From: Nolan, Chris <Chris.Nolan@lancashire.gov.uk>
Sent: 15 November 2017 10:54
To: Harriet McCartney; planning
Cc: LHS Customer Service
Subject: D3.2017.0993 - 22 Shireburn Avenue Clitheroe

Planning Application No: 3/2017/0993

Proposal: Removal of garage and erection of new integral garage with single storey rear and loft extension.

Location: 22 Shireburn Avenue Clitheroe BB7 2PN

Rev.	Description	By	Date
	Project Daniel Bone 22 Shireborn Avenue, Clitheroe, BB7 2PN	Drawing Title Proposed Layouts	
		Drawing No. BONE/02	Rev. A
		Drawn by J.L.	Scale 1:50
			Date Nov '17

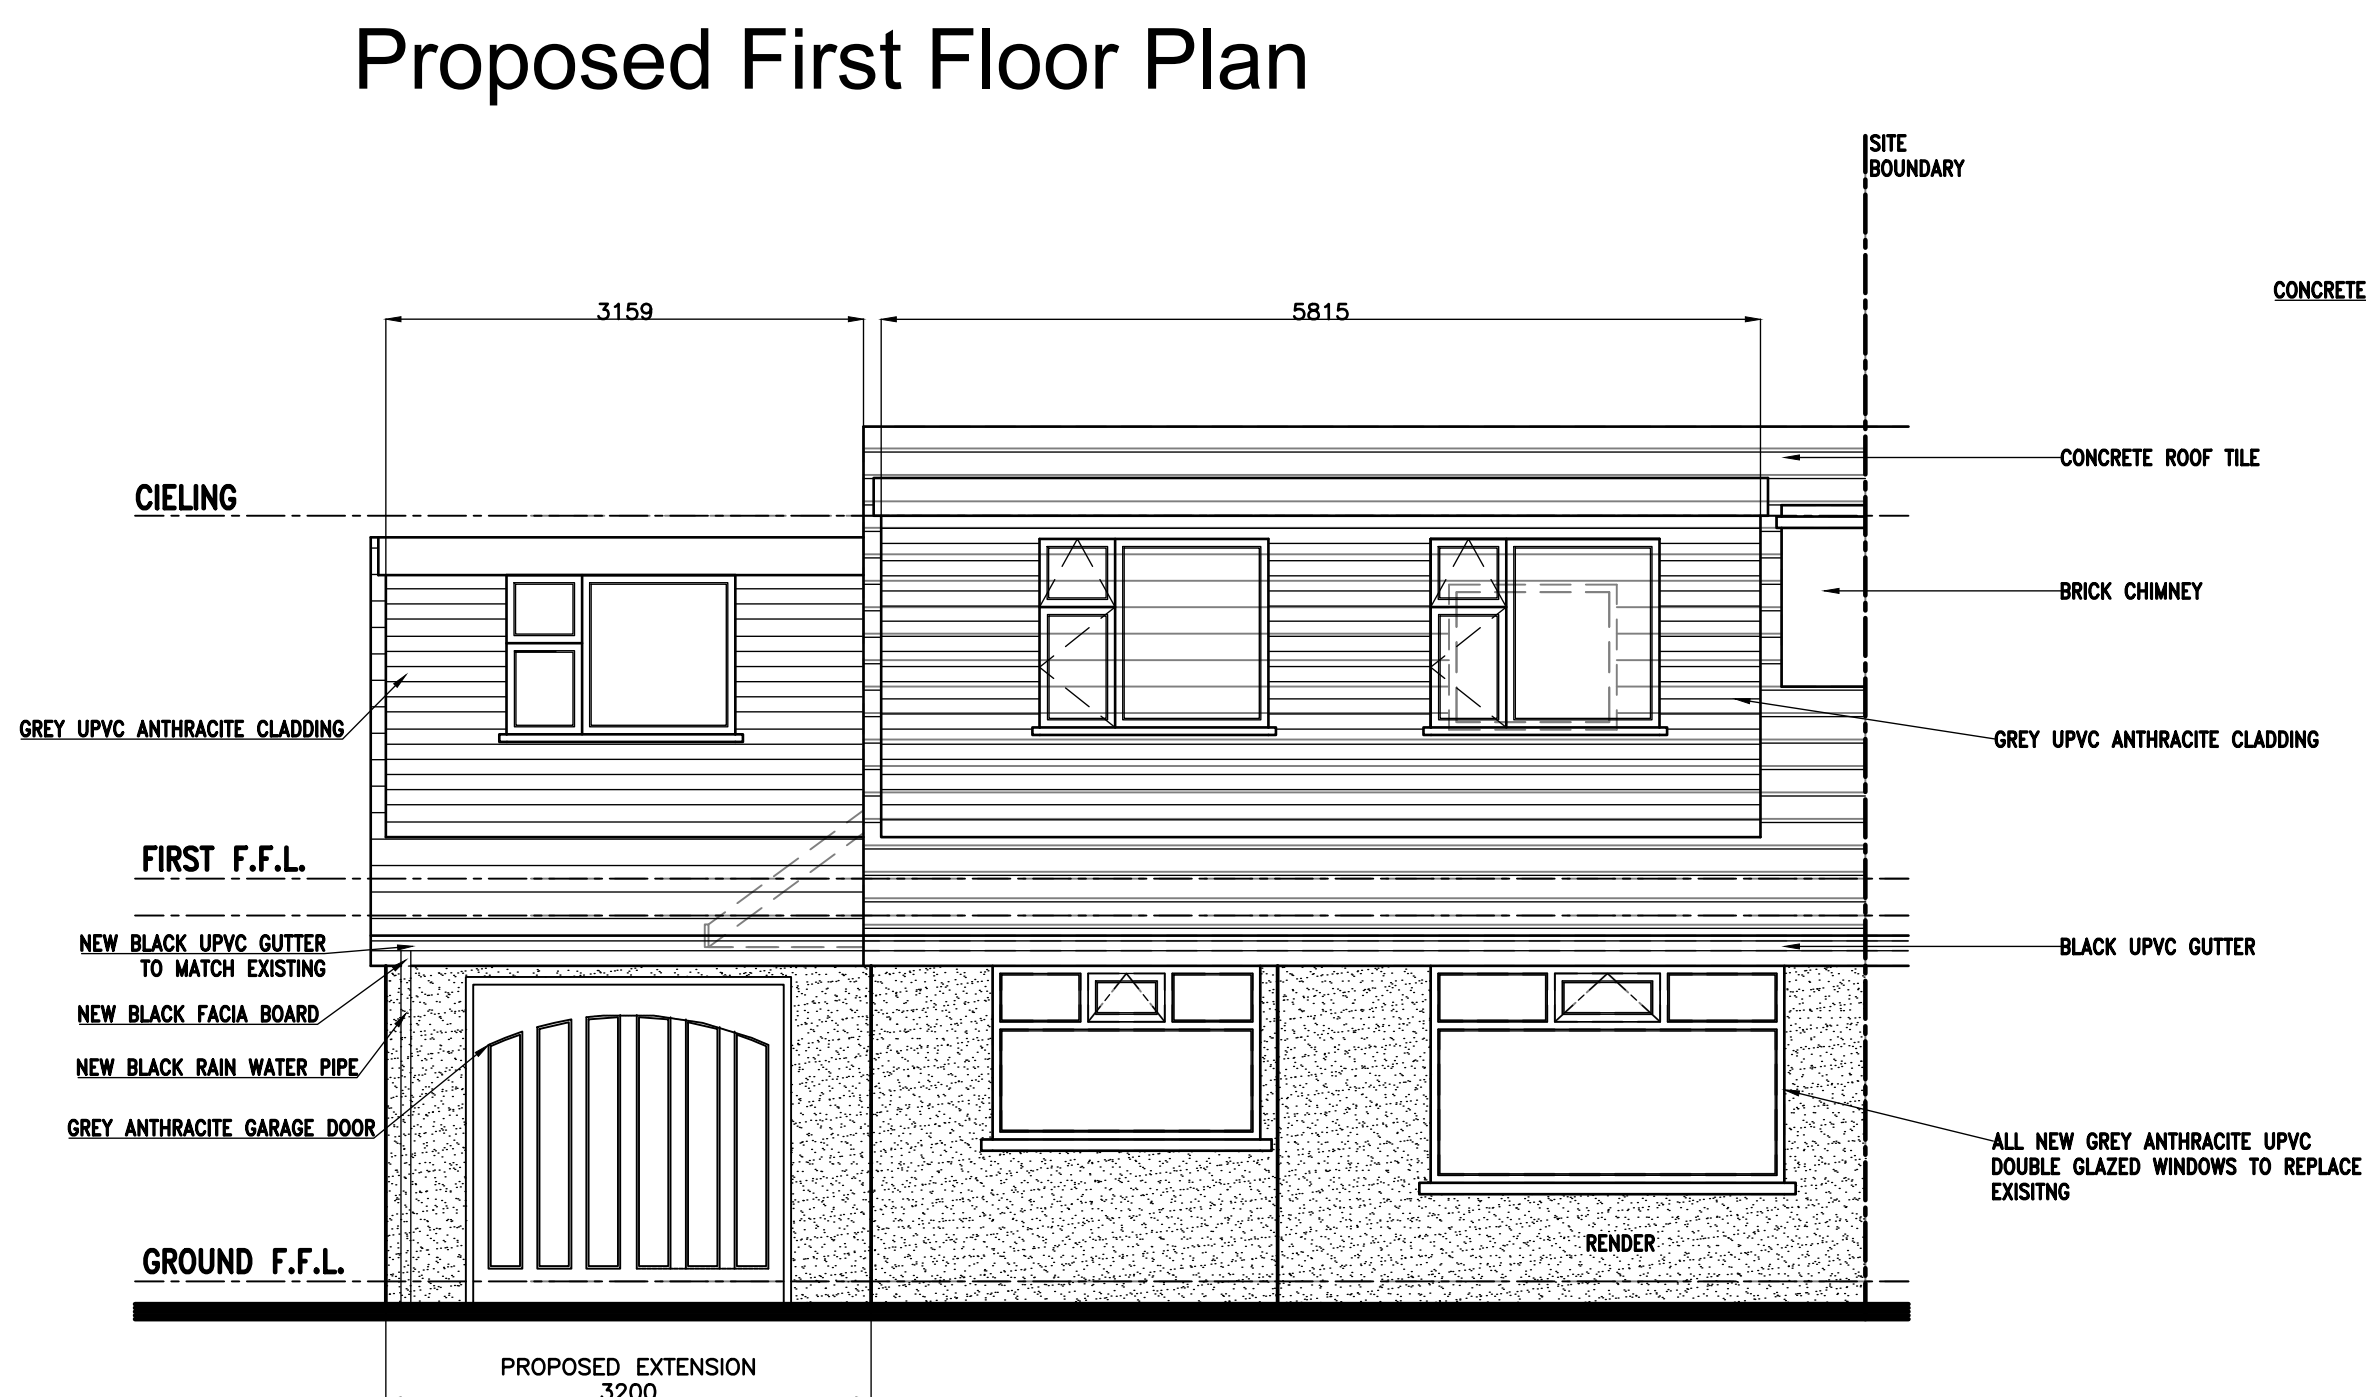
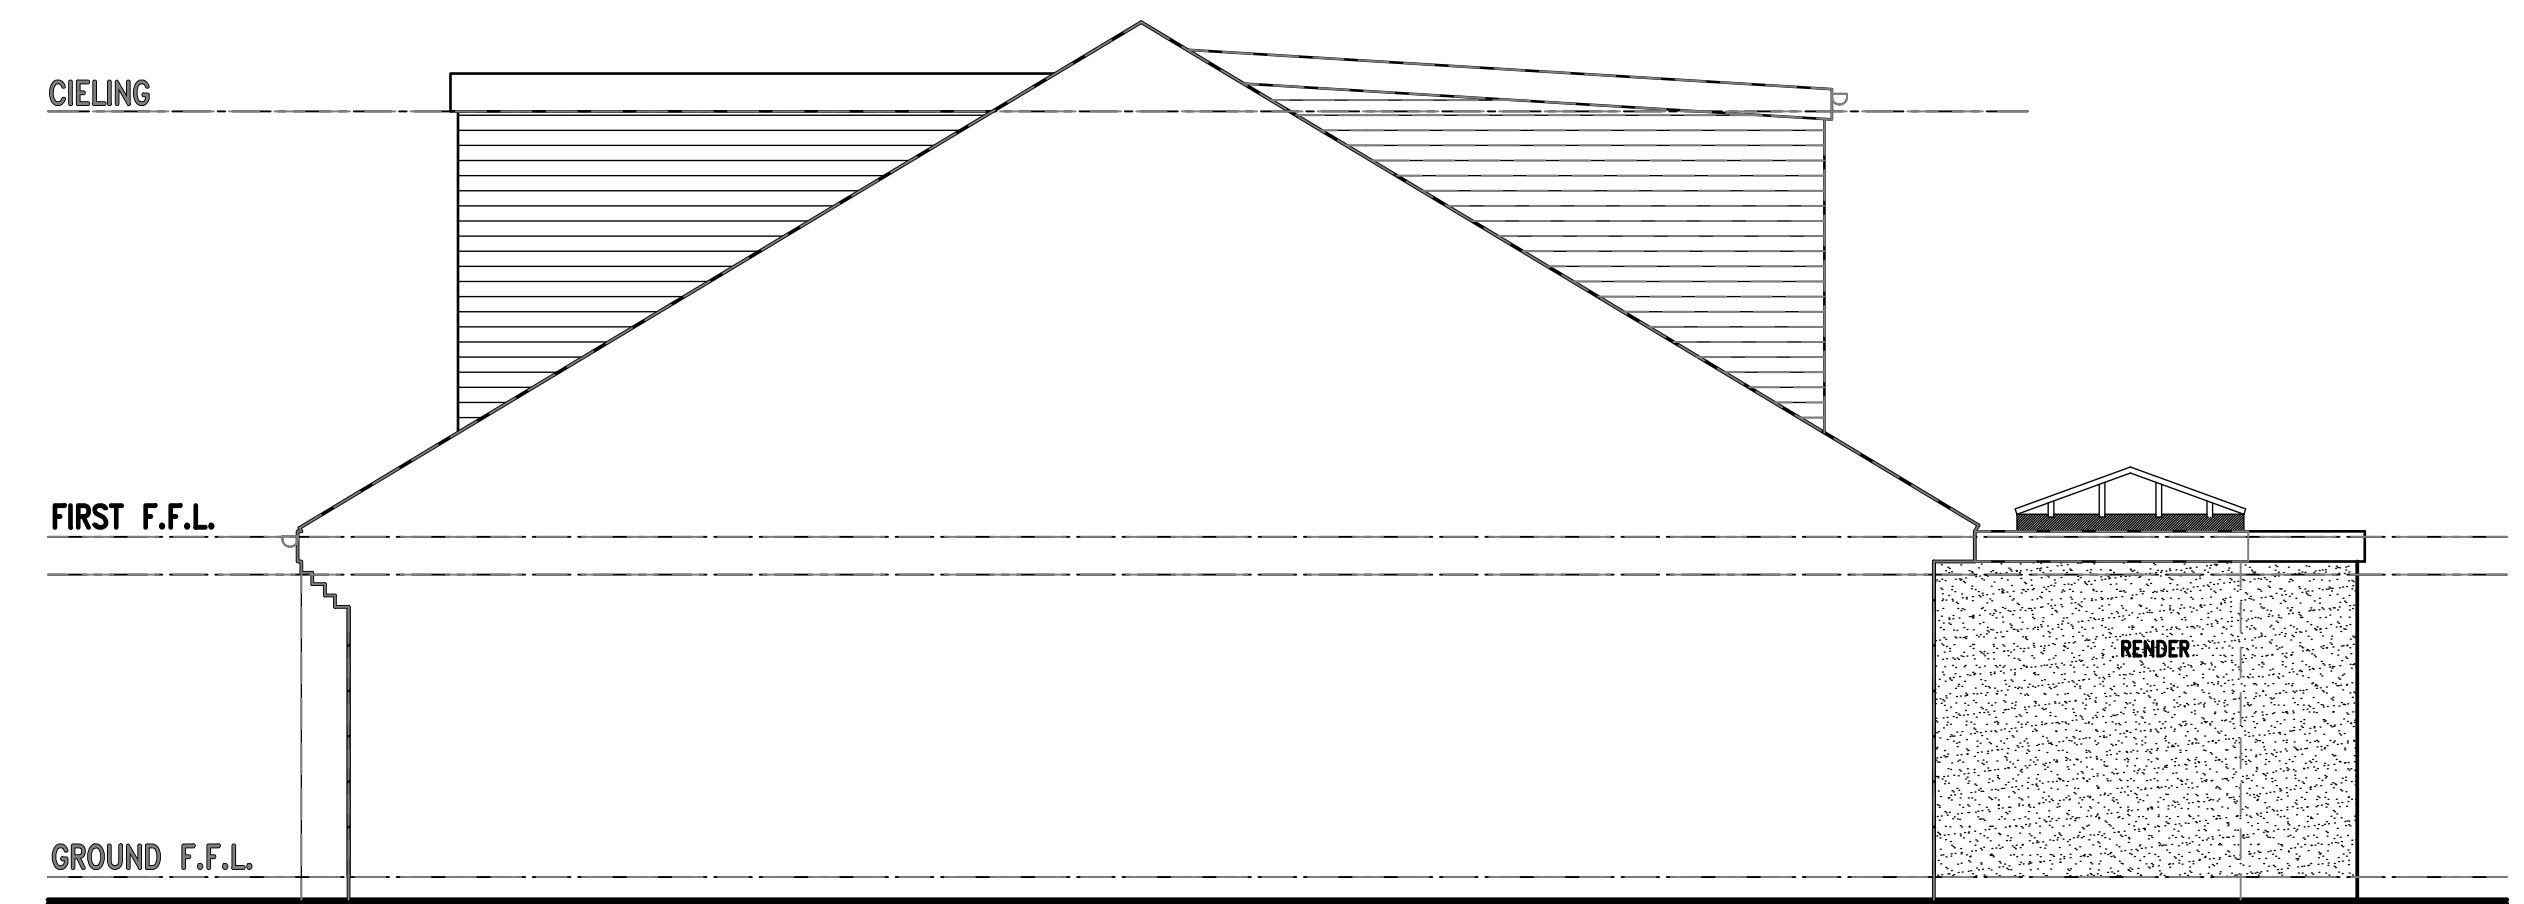
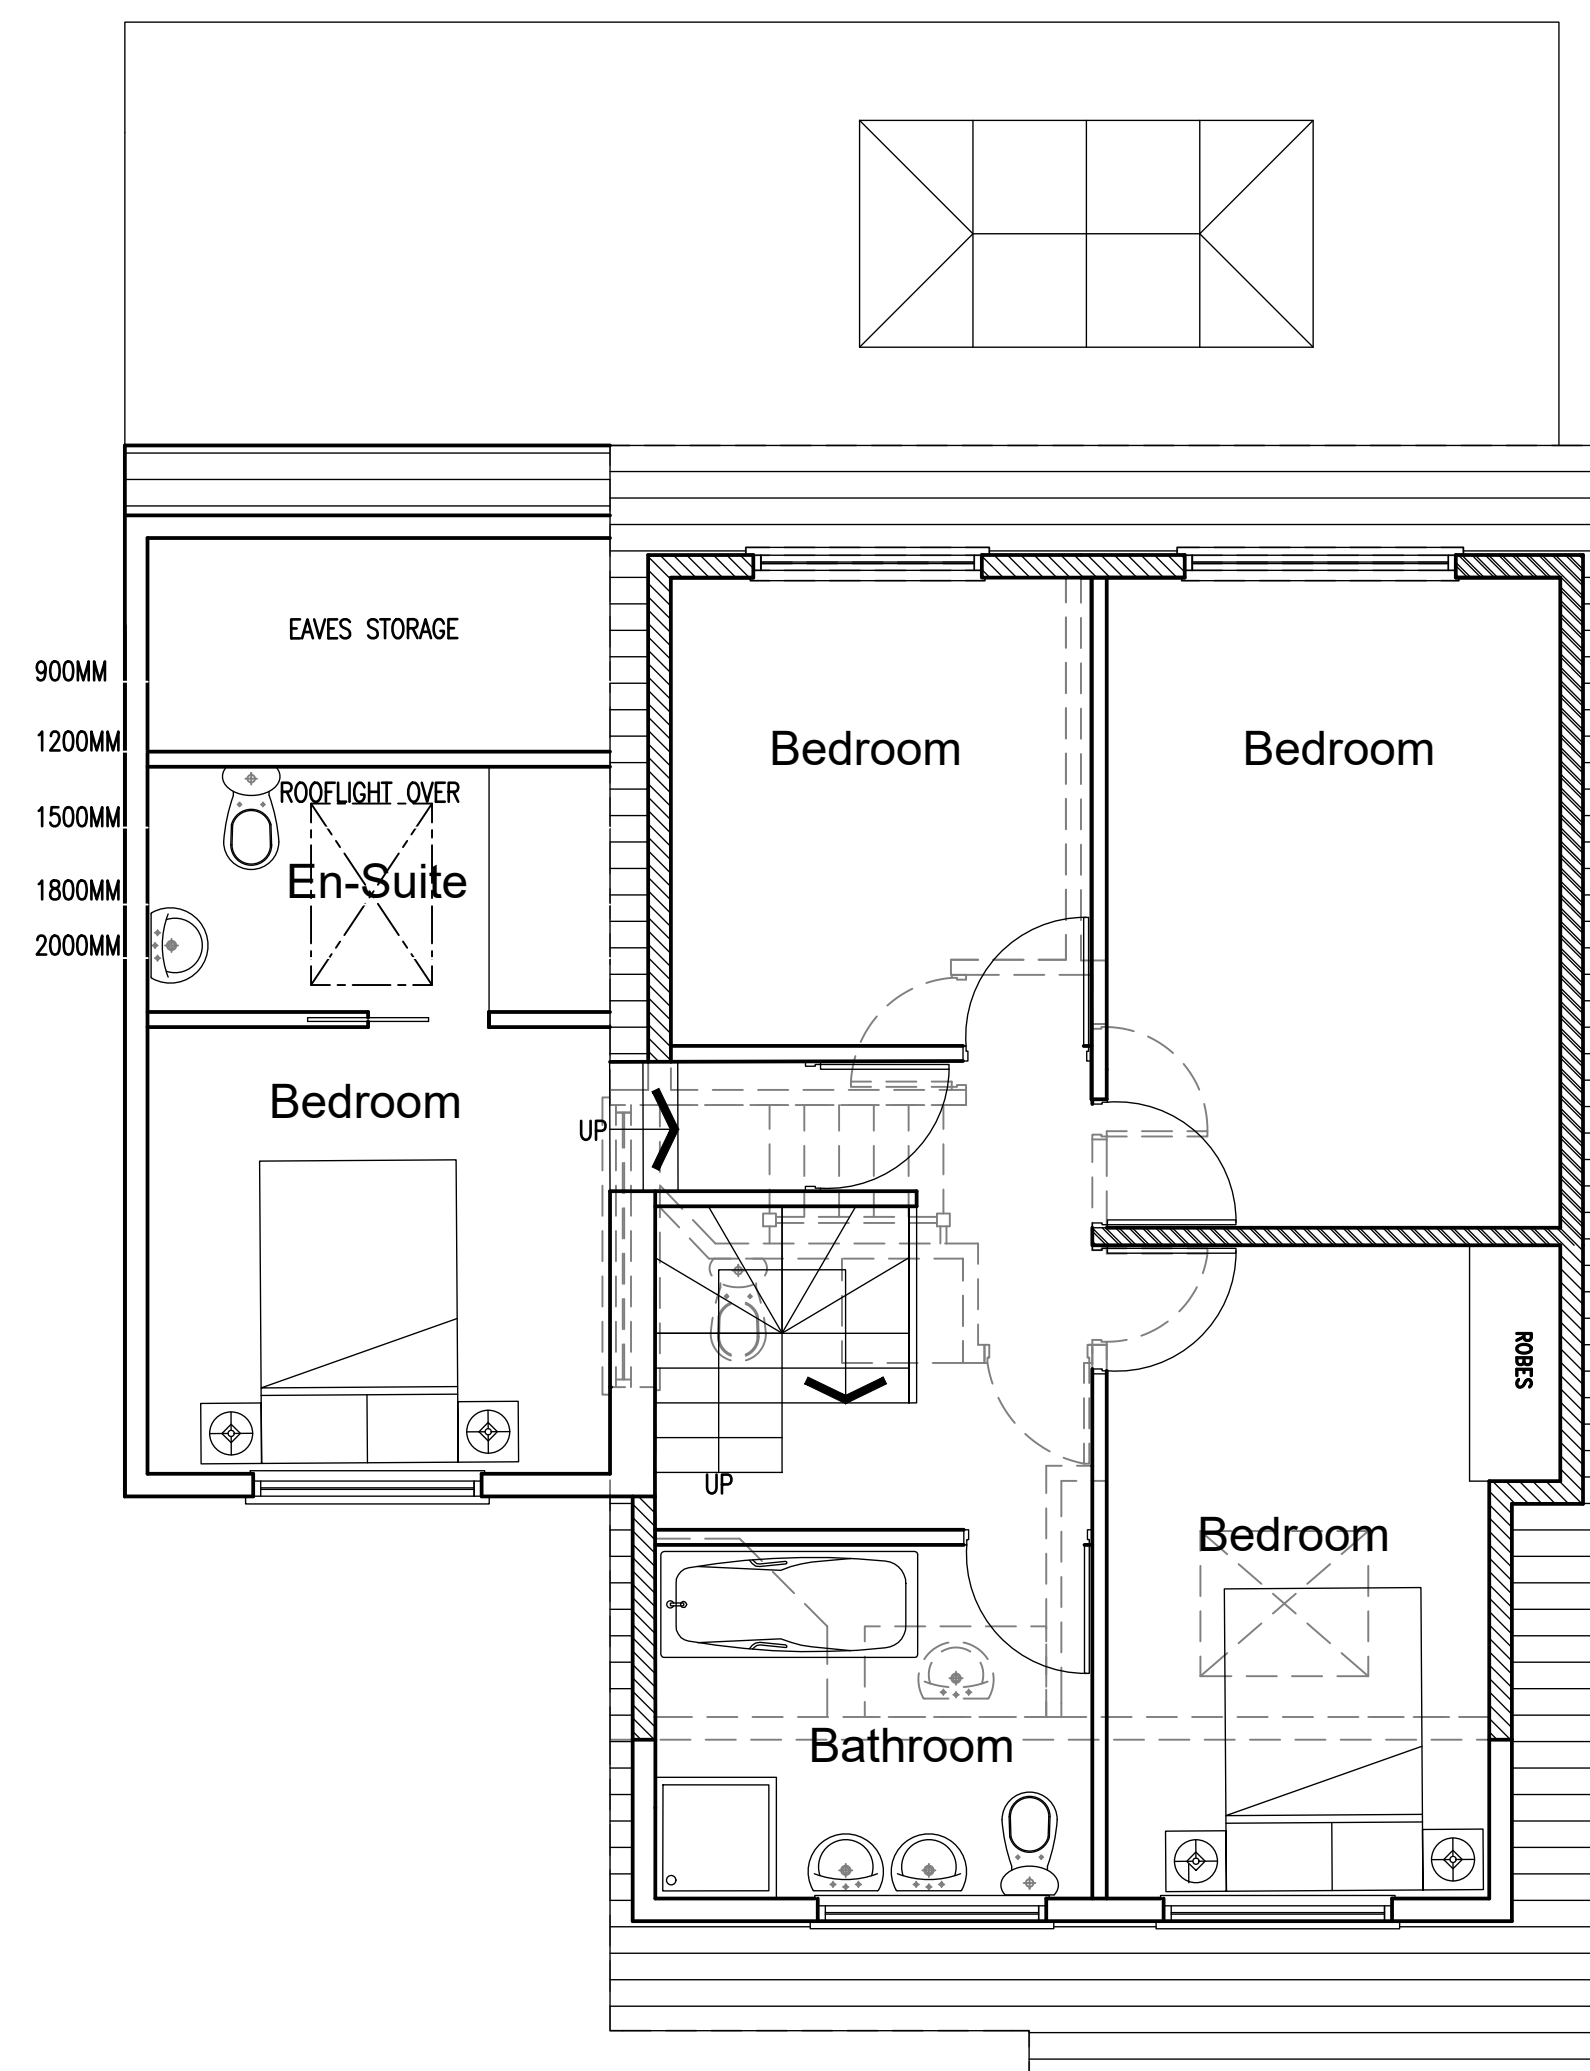
With regard to the above planning application. The proposal will increase the number of bedrooms from three to four whilst also making changes to the available parking. The plans indicate that the work will include the formation of a new garage space whilst removing the existing garage along with access to the existing garage. For a property with four bedrooms I would be look for sufficient parking for a total of three vehicles with in the curtilage of the property. Presently I do not have any plans indicating that this arrangement has been considered or is available.

The plans also indicate that the finished building will occupy the full width of the plot of 22 Shireburn Avenue. As this is the case I would need the plans of the parking arrangements to include plans for where bins are to be stored, to ensure that these do not compromise any of the necessary parking arrangements.
